SUNNICA ENERGY FARM

EN010106

8.82 FRA clarification document in light of proposed Scheme changes

Version	Date	Status of Version
Rev 00	13 January 2023	Submitted at Deadline 5
<u>Rev 01</u>	<u>30 January 2023</u>	<u>Submitted at Deadline 6</u>

Drawing file: EN010106 / EN010106-005257-6.3 Figure 3-2 Sunnica West Parameter Plan.pdf

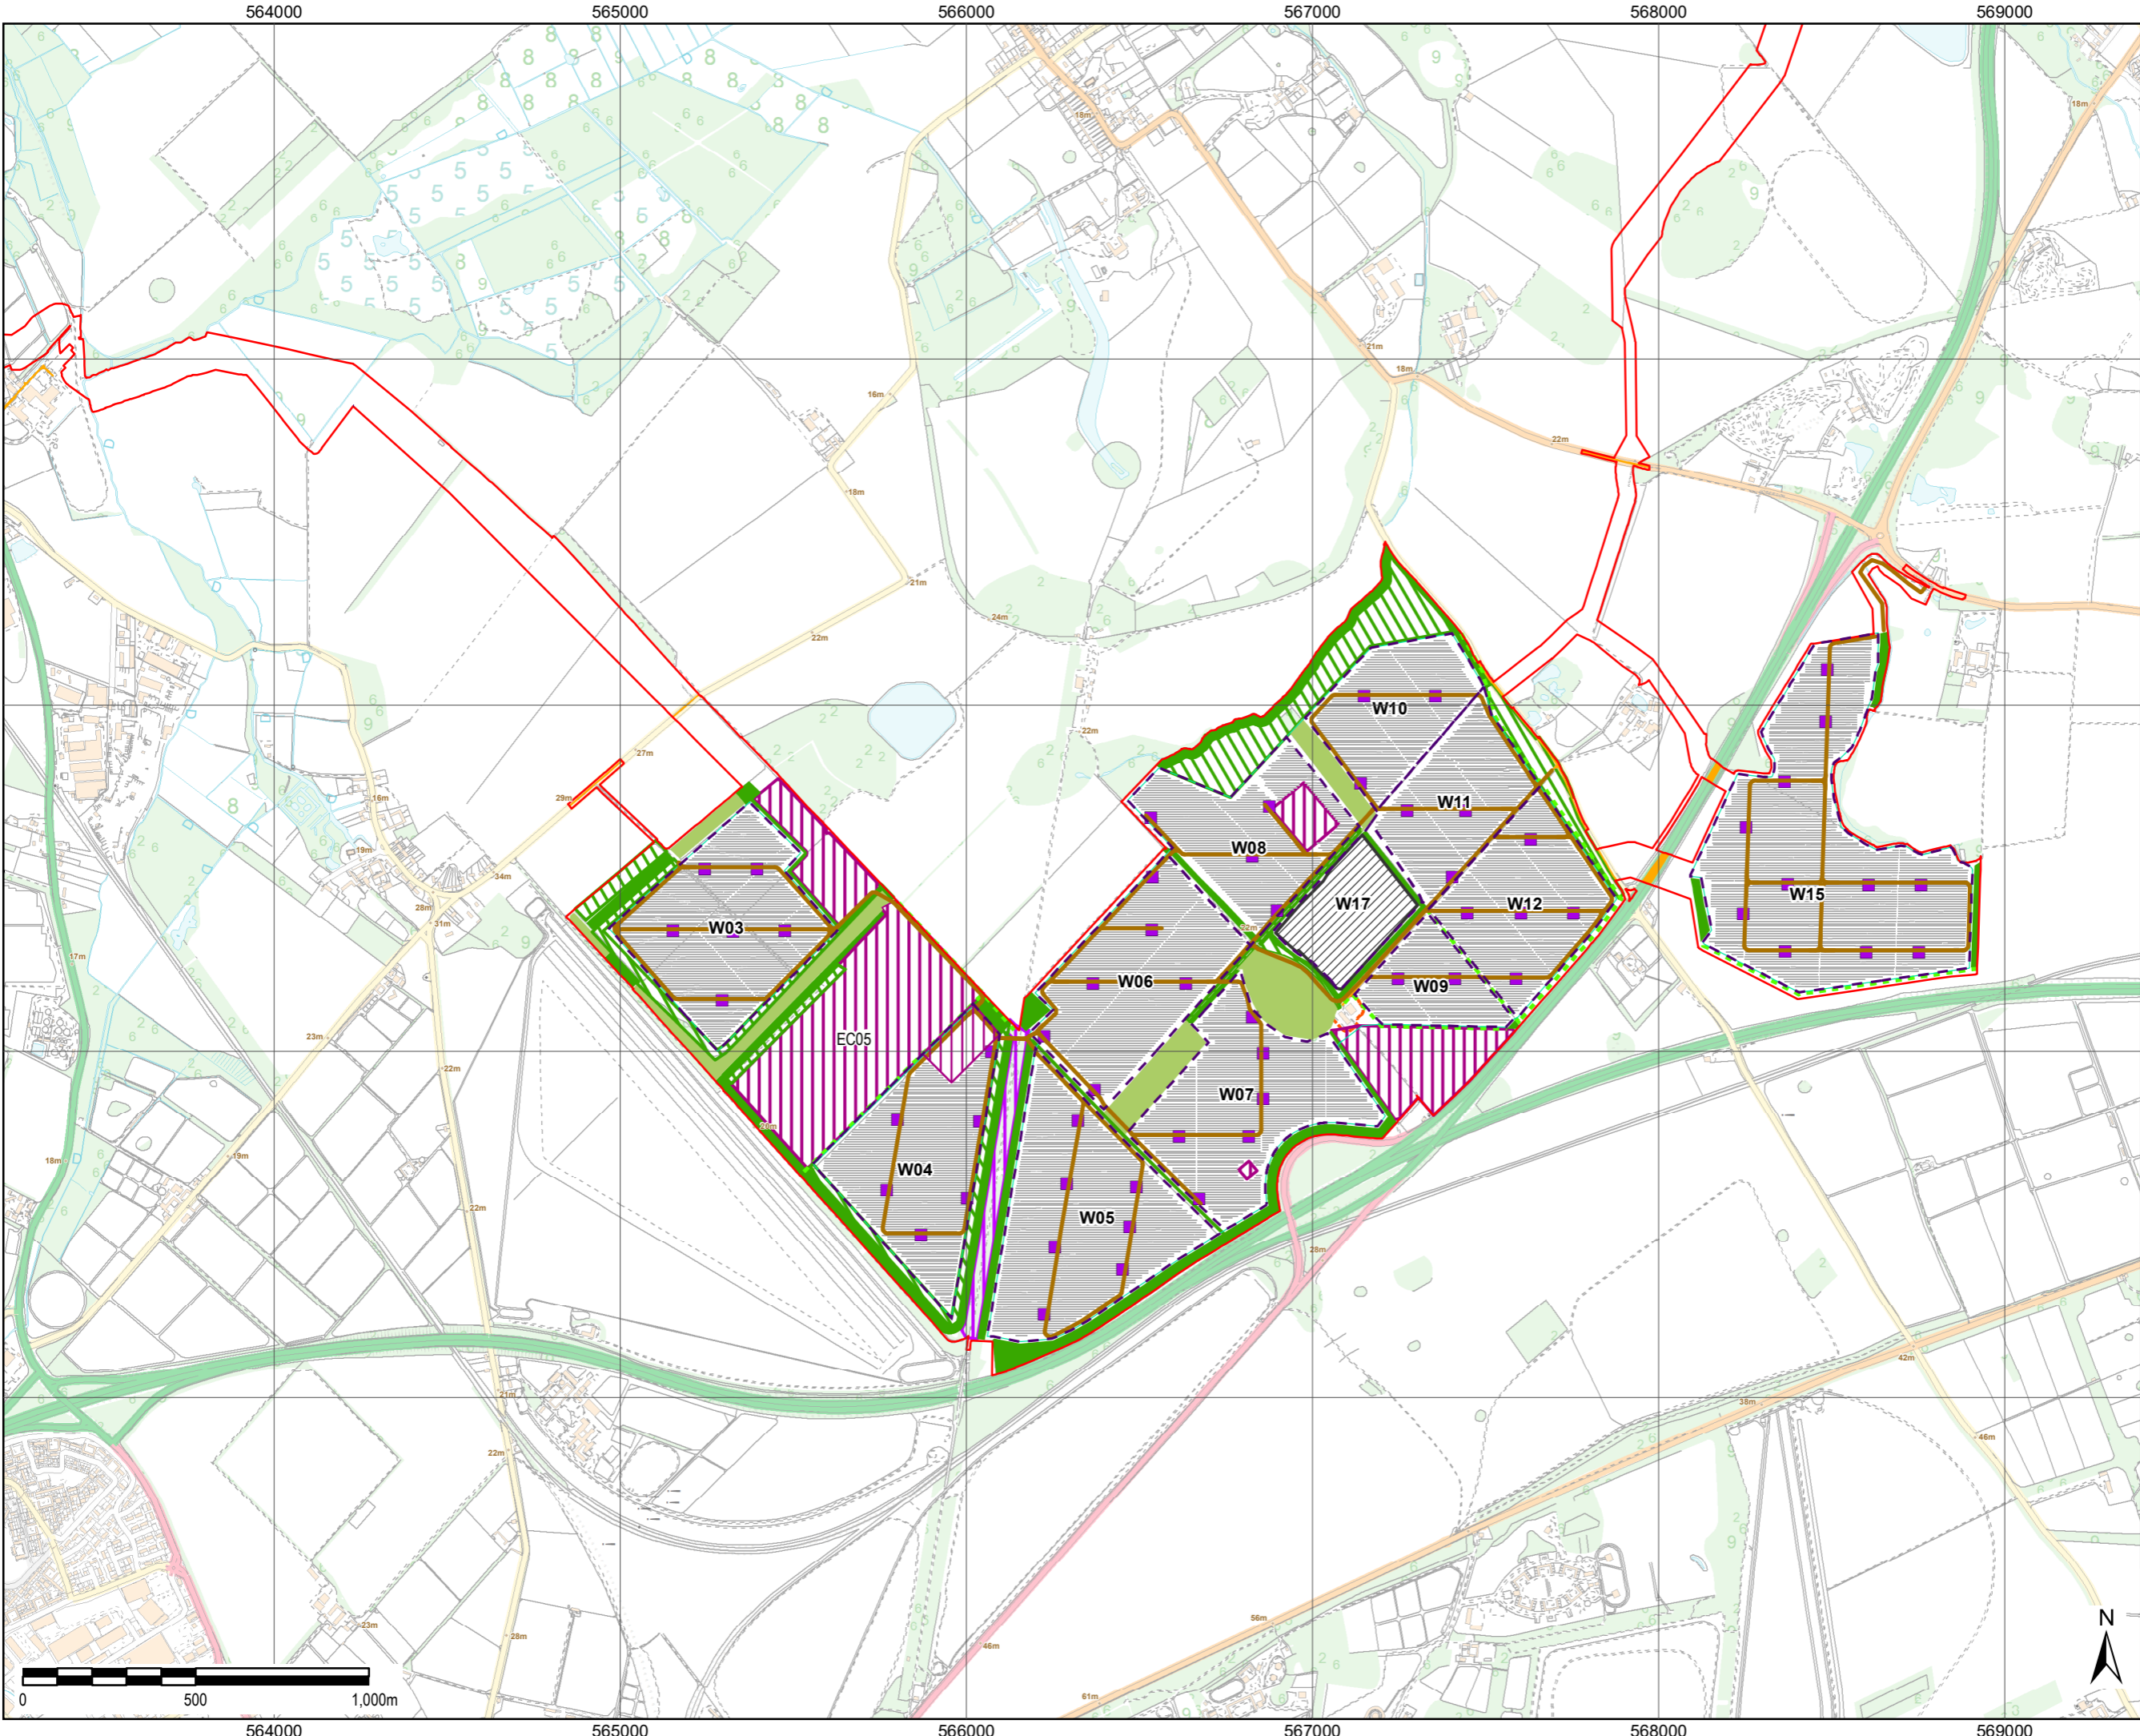
3. Change 2: Removal of Sunnica West Site B

~~1.1.28~~1.1.29 With the removal of Sunnica West B and Option 2 for Burwell substation, the revised total area of the Order limits has reduced from 1,113 ha to 1,059 ha.

~~1.1.30~~1.1.31 The developable areas for Sunnica East Site A and B and Sunnica West Site A remain unchanged. With removal of Sunnica West B the total developable area has reduced from 621 ha to 598 ha, a reduction of 23 ha. The remaining areas (461ha) will be set aside for environmental and archaeological mitigation and cable routes.

~~1.1.31~~1.1.32 The Drainage Strategy has been reviewed to take into account the reduced Scheme area and the SuDS proposals to ensure the outline strategy is still compliant. All SuDS proposals have been removed from the area of Sunnica West Site B as there is no proposed permeant above ground built development.

~~1.1.34~~1.1.35 Flood risk will, in effect, be reduced in this area as only cable routes will pass through this area, between W17 and Burwell substation. Cable routes have been previously assessed as having no long term flood risk impact as there is no permanent above ground built infrastructure being placed, with all cabling installed below ground.

~~1.1.41~~1.1.42 Change 2 reduces post scheme flood risk in the area of Sunnica West B, to no change from existing flood risk from all sources. Cable routes will still pass through but will be buried.
